SETTLERS RANCH SUBDIVISION FILING NO. 3

A REPLAT OF A PORTION OF SETTLERS RANCH SUBDIVISION FILING NO. 2C, AND A PORTION OF SETTLERS RANCH ROAD, FILING NO. 2B, LOCATED IN A PORTION OF THE SOUTHEAST QUARTER (SE1/4) AND A PORTION OF THE SOUTHEAST QUARTER OF THE NORTHEAST QUARTER (SE1/4 NE1/4) OF SECTION 23, AND THE SOUTHWEST QUARTER (SW1/4) OF SECTION 24, ALL IN TOWNSHIP 11 SOUTH, RANGE 66 WEST OF THE 6th P.M., EL PASO COUNTY, COLORADO.

REVISED: JULY 3, 2024
DATE OF PREPARATION: JULY 31, 2023
PFD FILE #: SF2349

V2_Final Plat Drawings comments.pdf Markup Summary

22. MAXIMUM BUILDING HEIGHT: 30 FEET

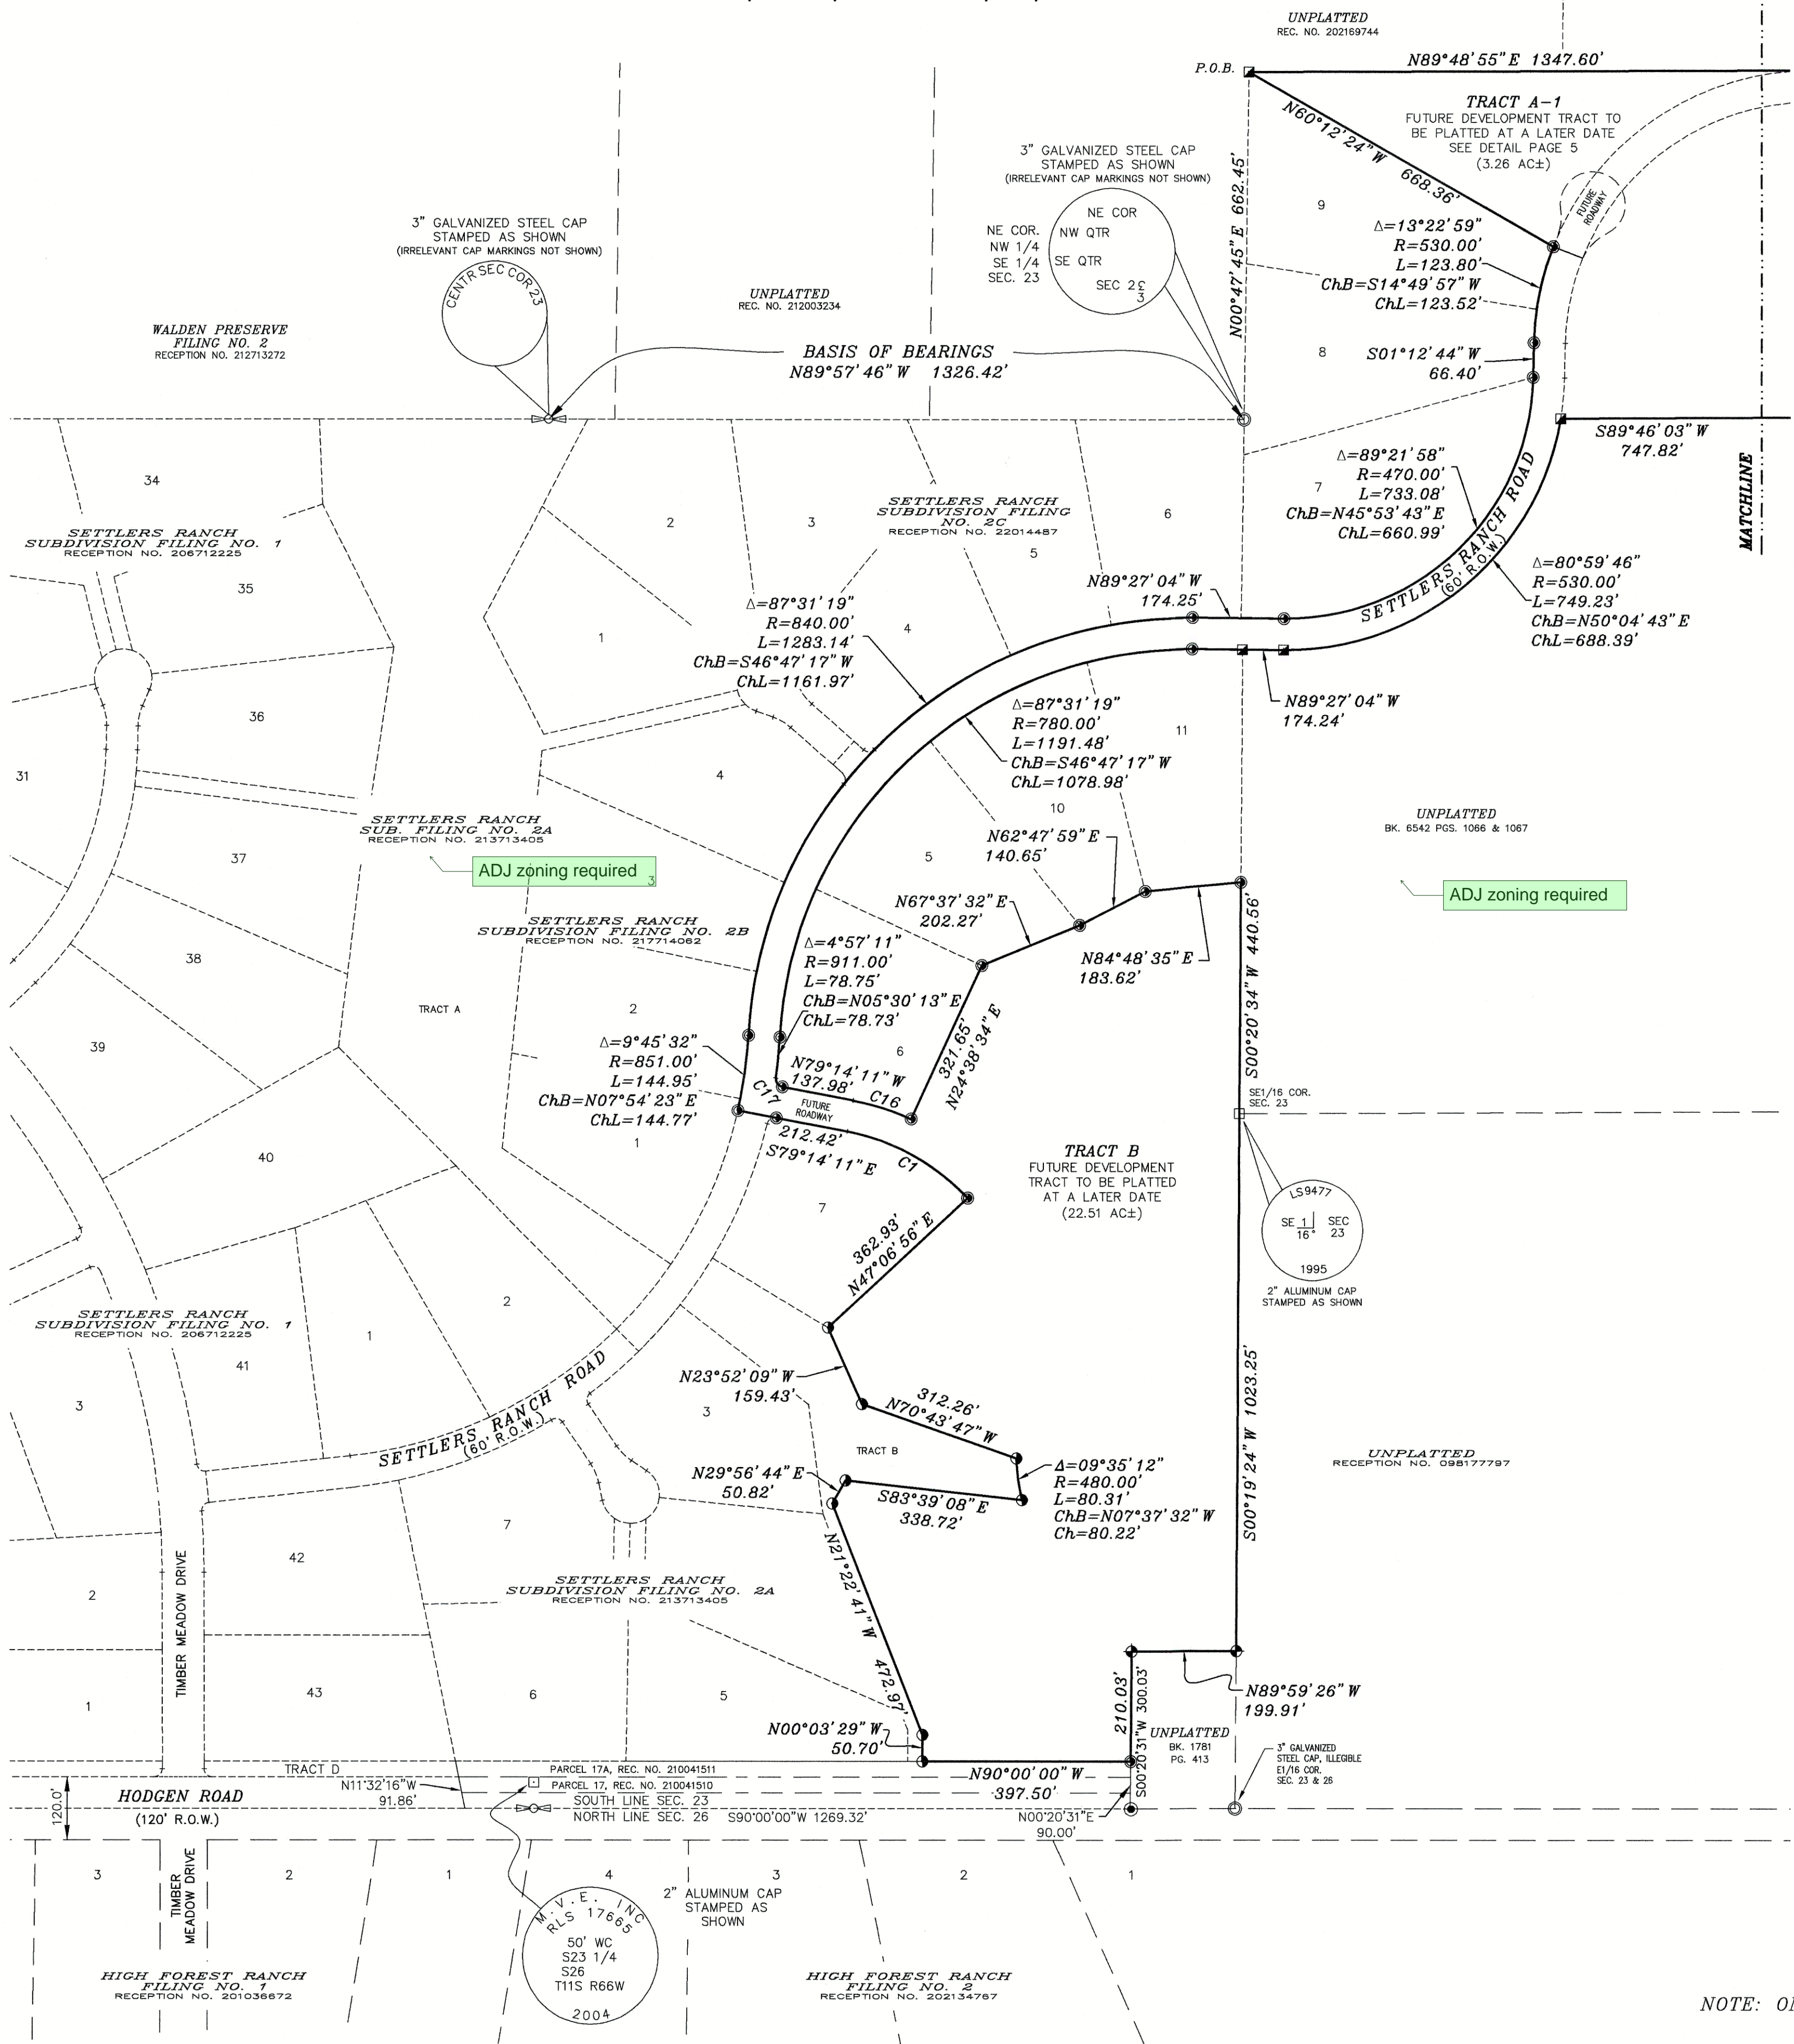
Is this an existing easement and then you are creating new easements w this plat? Does this easement go away?

Update #
lots

no report on file delete 2 delete this will be RR2.5 not PUD

setbacks still incorrect. RR2.5 zoning applies just like RR 2.5
